CITY OF ALBUQUERQUE

June 26, 2023

**RE: Starbucks - Tramway
Grading and Drainage Plans
Engineer's Stamp Date: 06/12/23
Hydrology File: L23D015A**

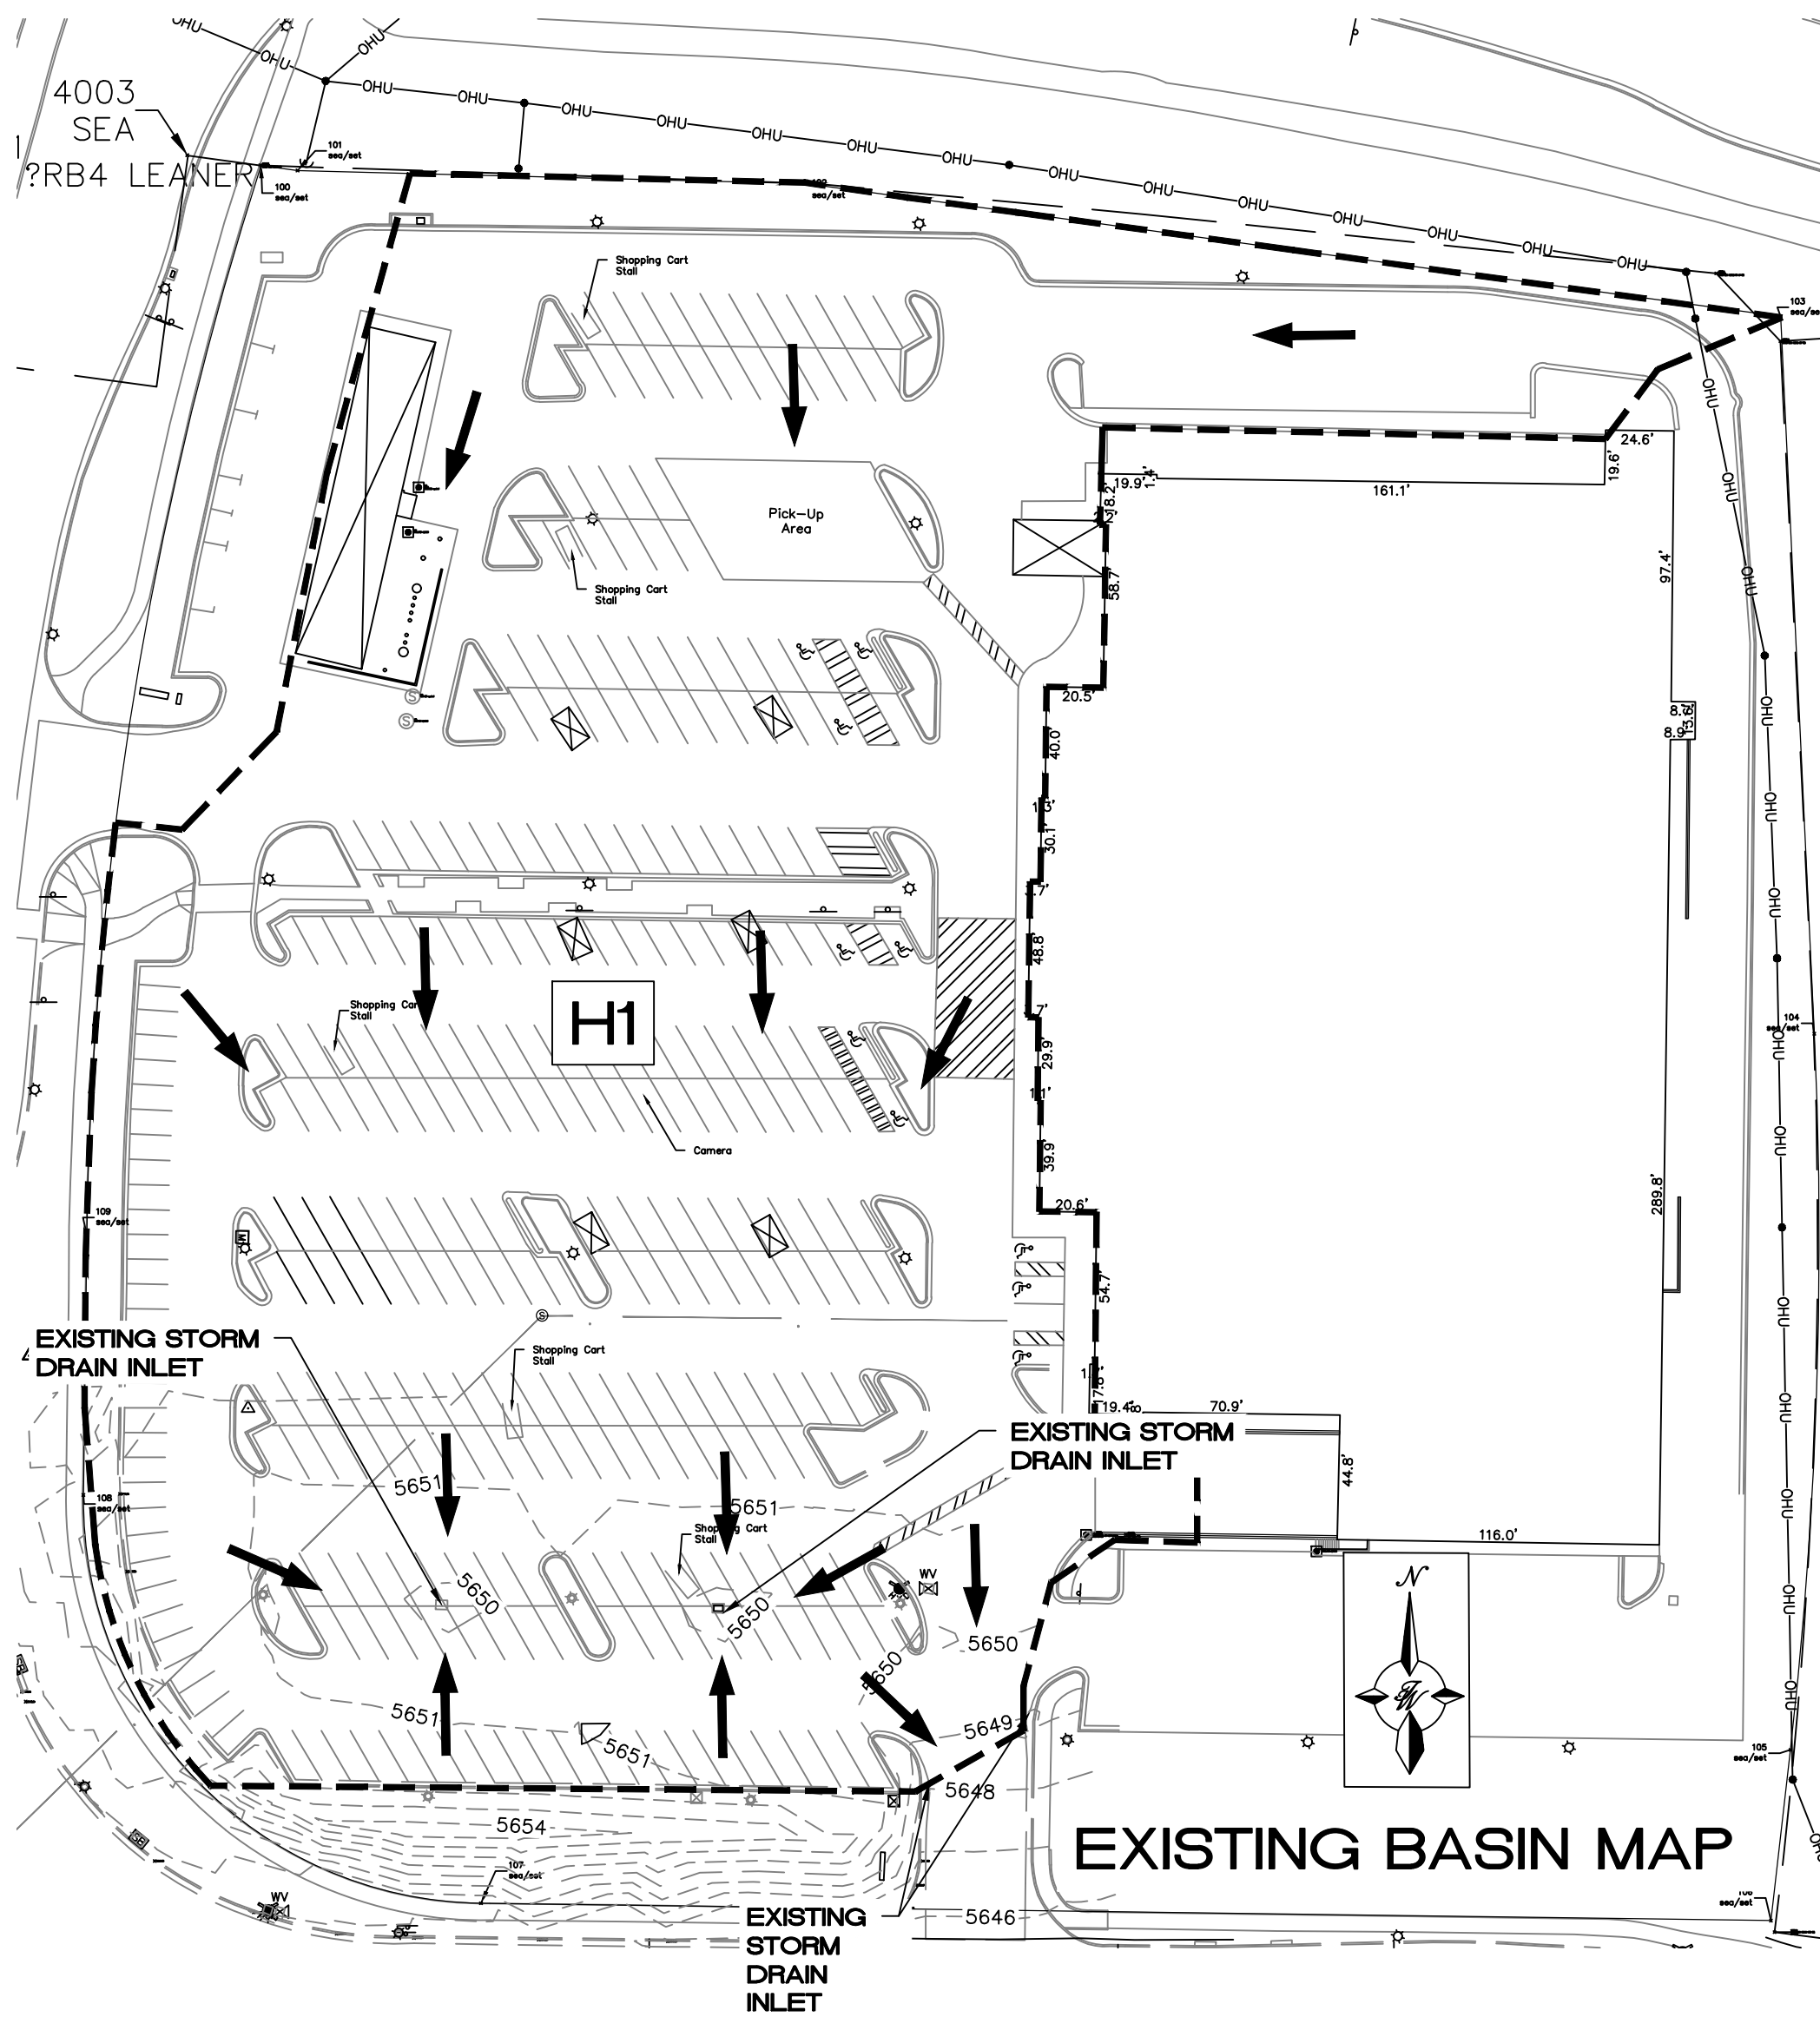
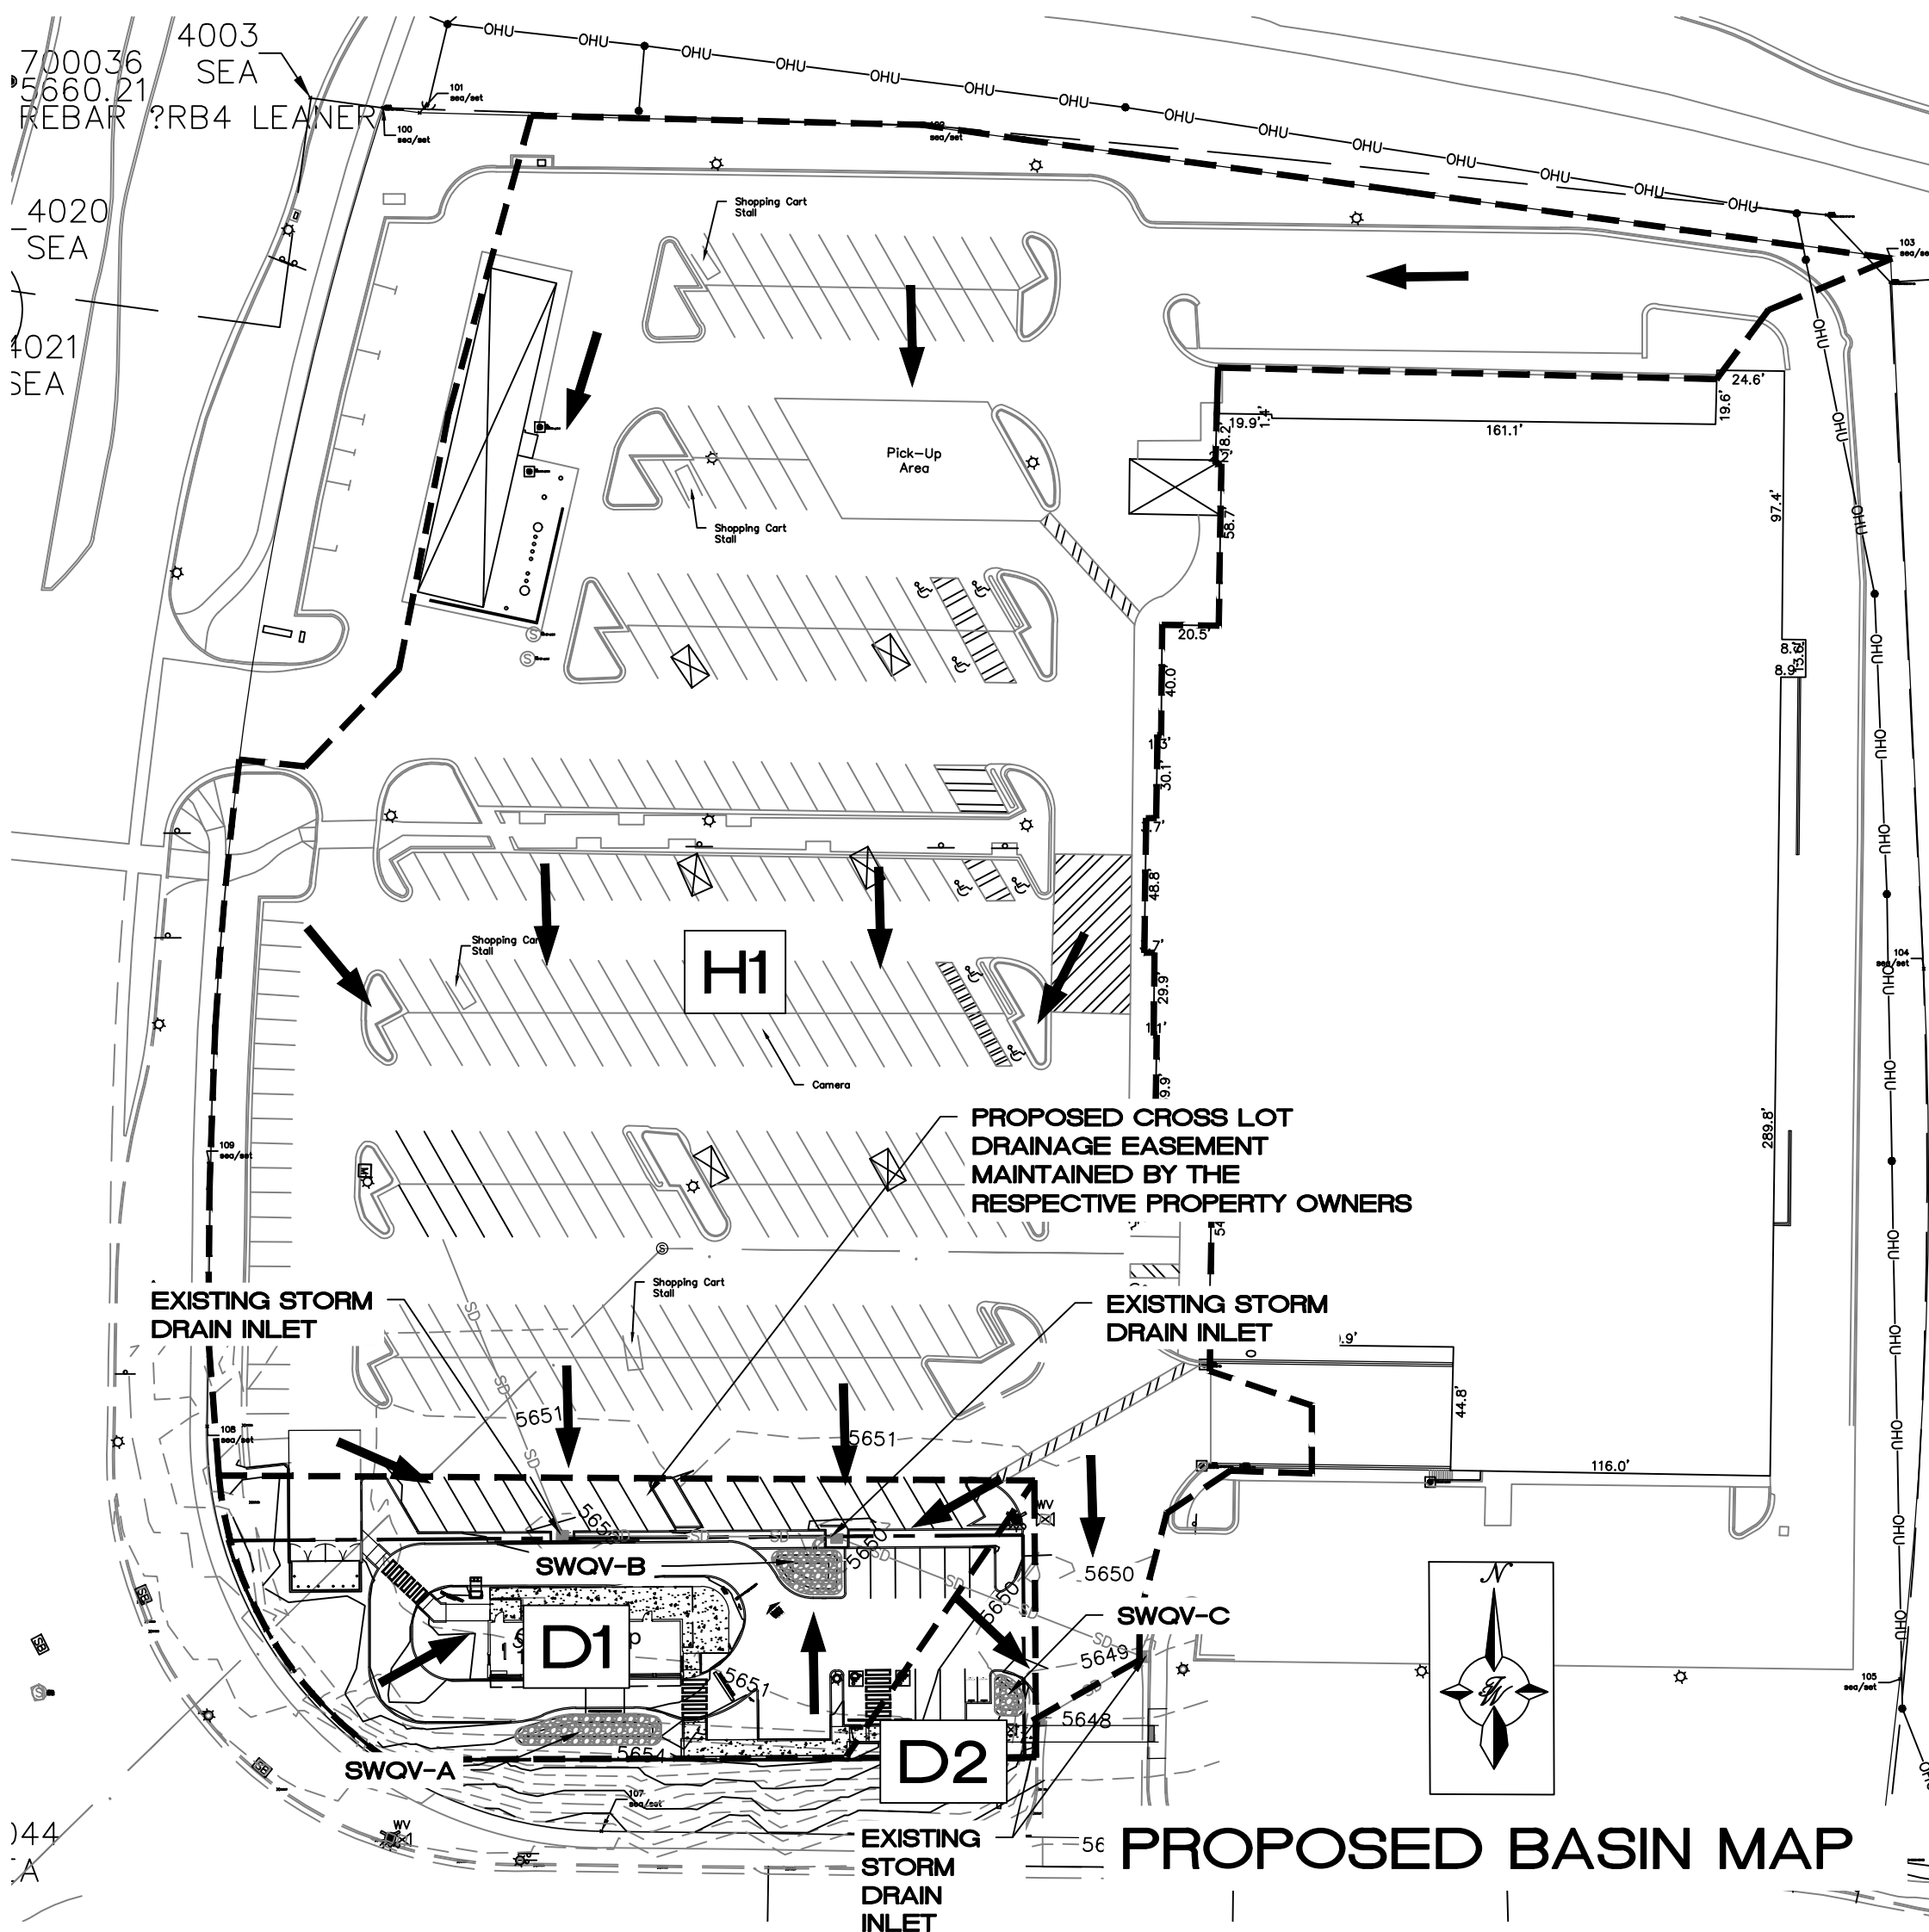
1. For the Existing Conditions, please show the whole drainage area for the existing two drainage inlets. This is Area B in the original Smith's plans. Please do a better solution to handling the placement of the existing inlets.

- SWQ Pond A does not get any drainage from this proposed development, therefore the pond needs to be relocated within the development and should get drainage.

ENGINEER'S SEAL	STARBUCKS ON TRAMWAY ALBUQUERQUE, NM	DRAWN BY BF
		GRADING & DRAINAGE PLAN	DATE 07/11/2023
	RONALD R. BOHANNAN P.E. #7868	TERRA WEST, LLC 5571 MIDWAY PARK PLACE NE ALBUQUERQUE, NM 87109 (505) 858-3100 www.tierawestllc.com	2023047_GRE
SHEET # <b>C2</b>			JOB # 2023047

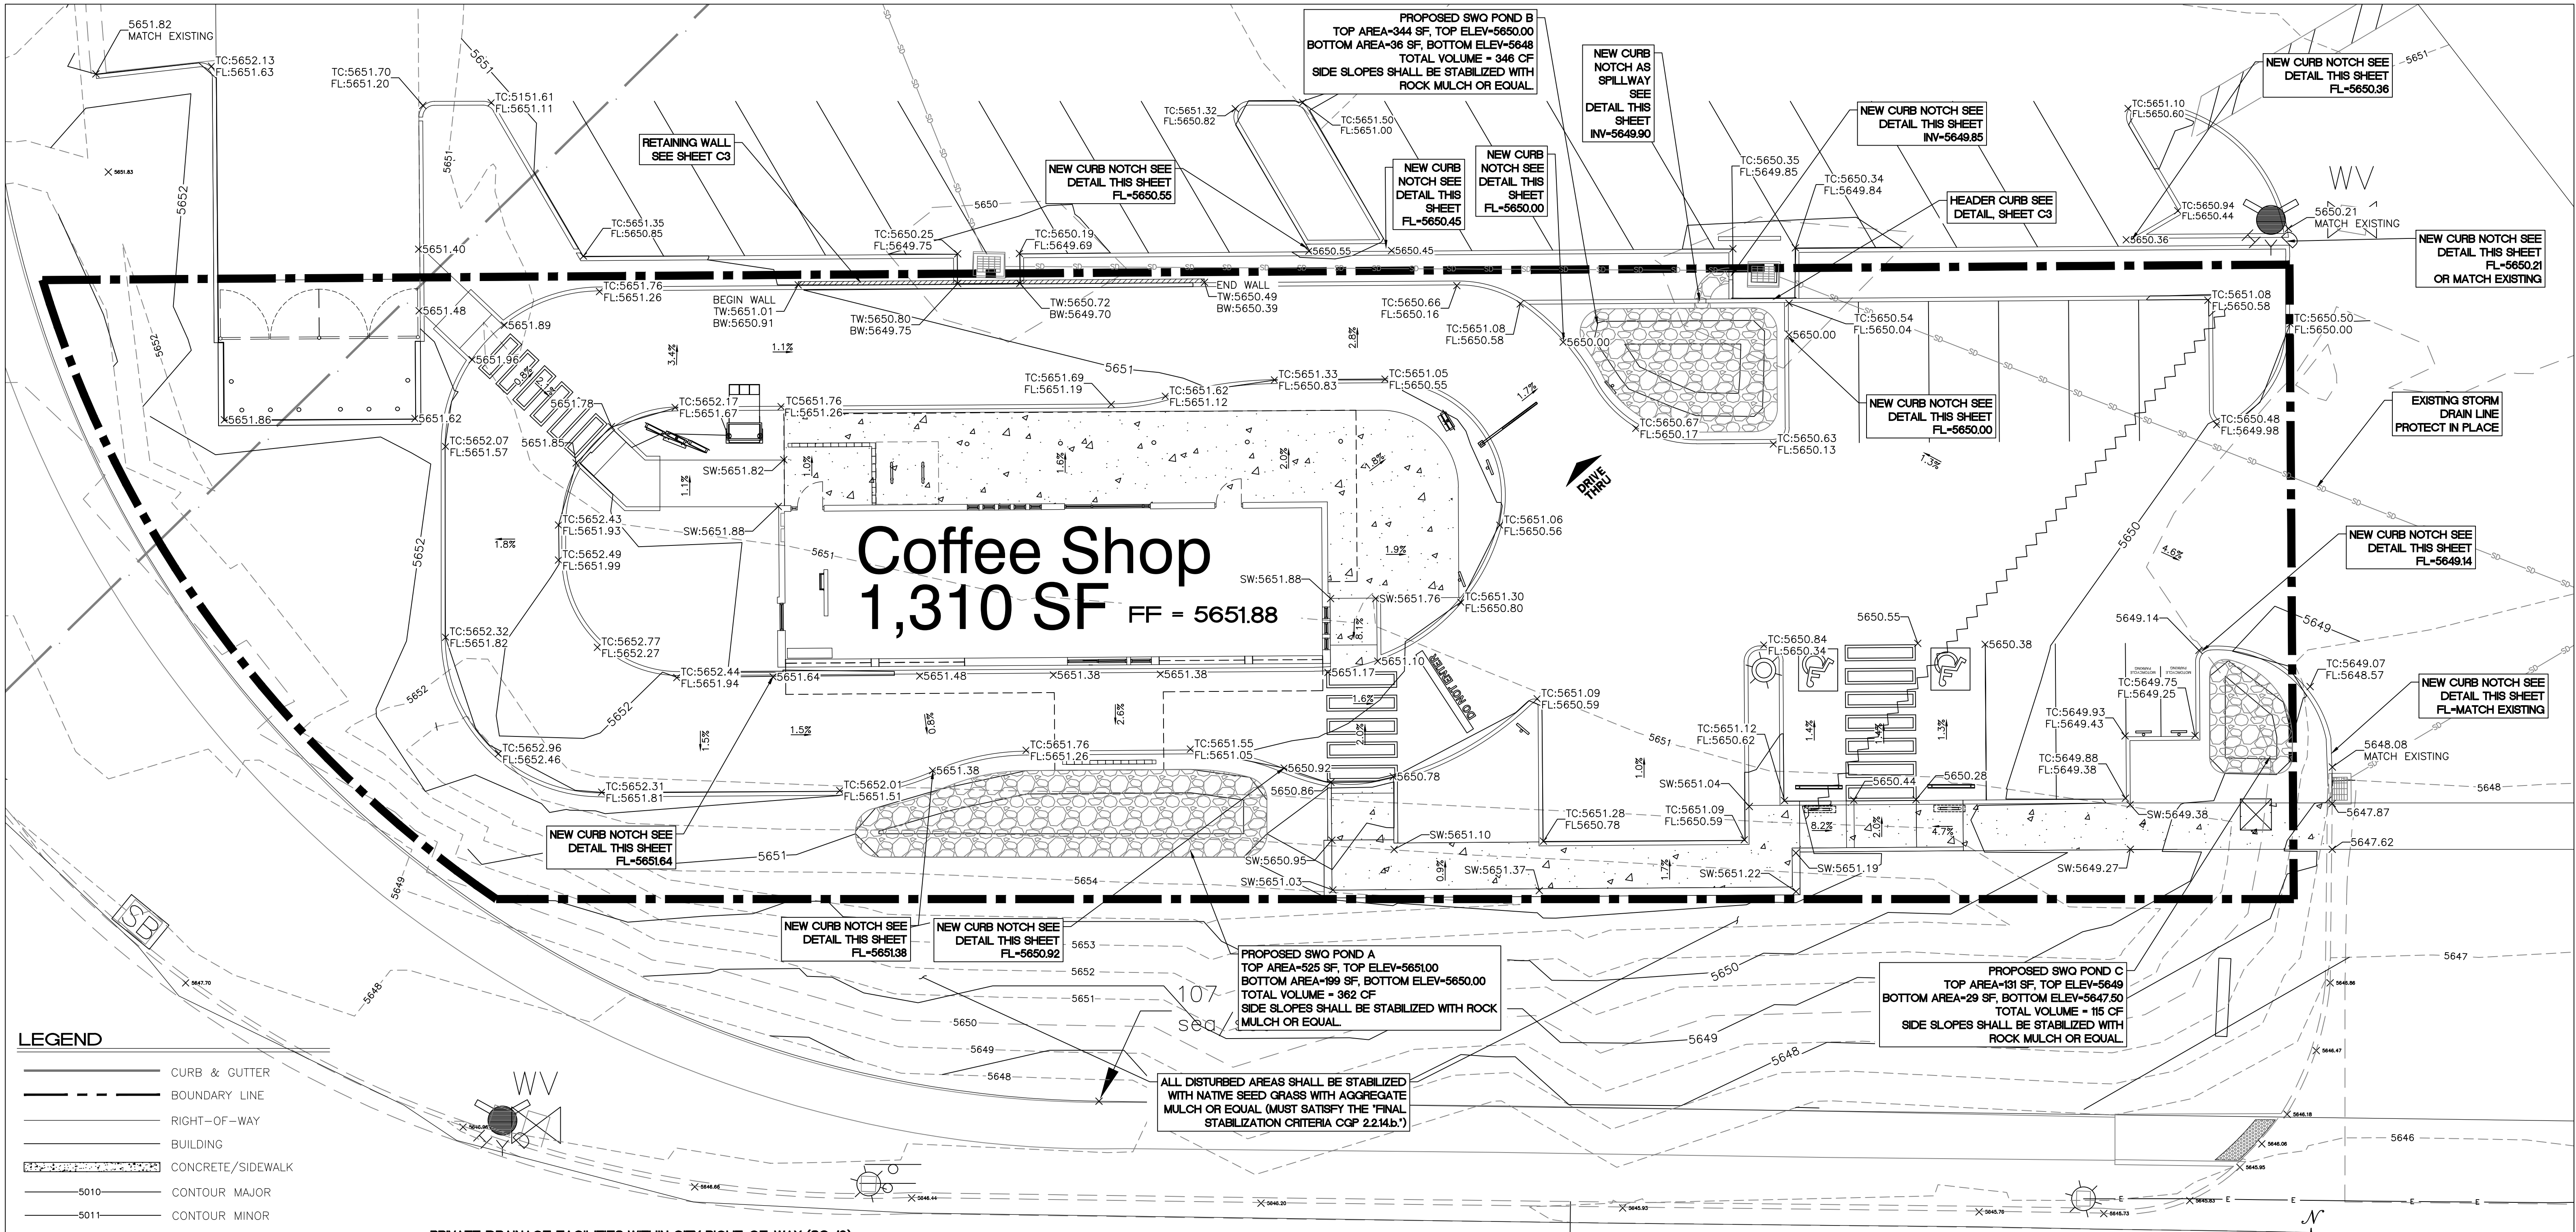
- Please adjust the grades. They do not currently flow the direction of the flow arrows. You have a flowline of 51.97 on the high side and a flowline of 52.00 on the low side.

- Please show the private storm sewer lines. The contractor will need to know where these are location so that they do not damage them during construction.
